Letter No. A1/20824/2005.

Sub: CMDA - Planning Permission - Construction
of Ground Floor Residential building at Plot
No.2, Rajiv Gandhi Street, in S.No.246/5B of
Perungalathur Village - Development charge
and other charges to be remitted - Regarding.

SITE/GROUND FLOOR PLAN
ROAD.

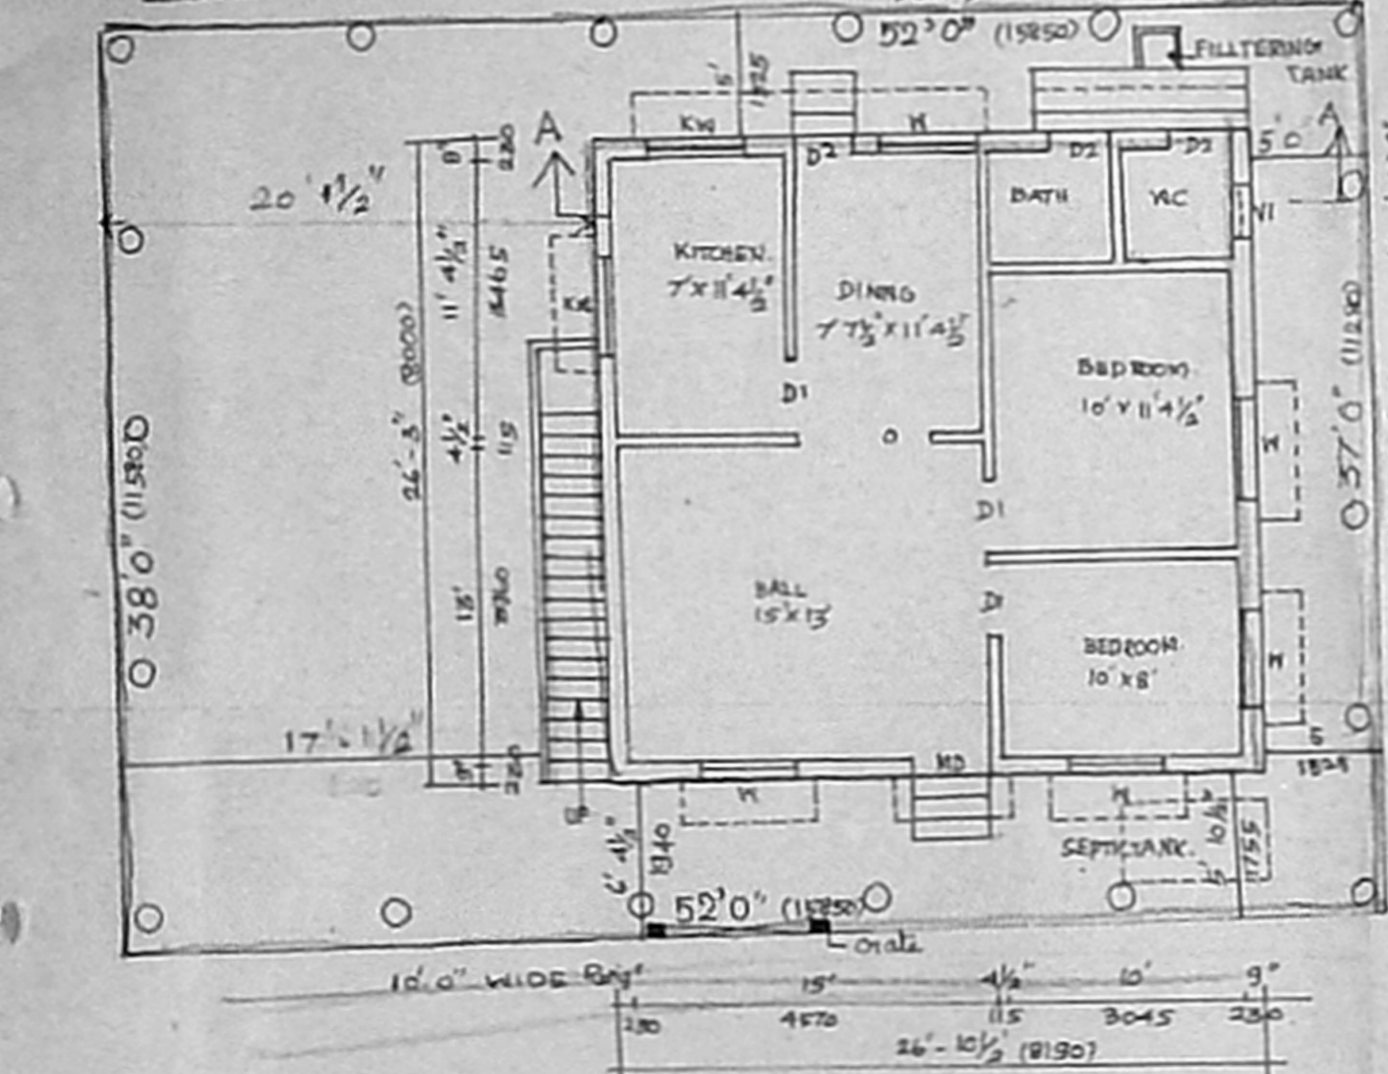
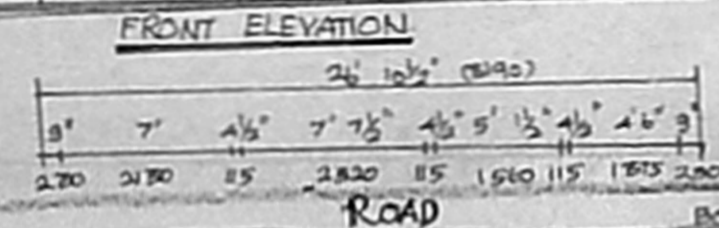
- a) Width of Roads to be mentioned in the site plan.
- b) Compound wall cum gate details with 7.5cm height dwarf wall and gate position in the site plan not mentioned.
- c) Residuary plot details not furnished from exist of 19 cents.
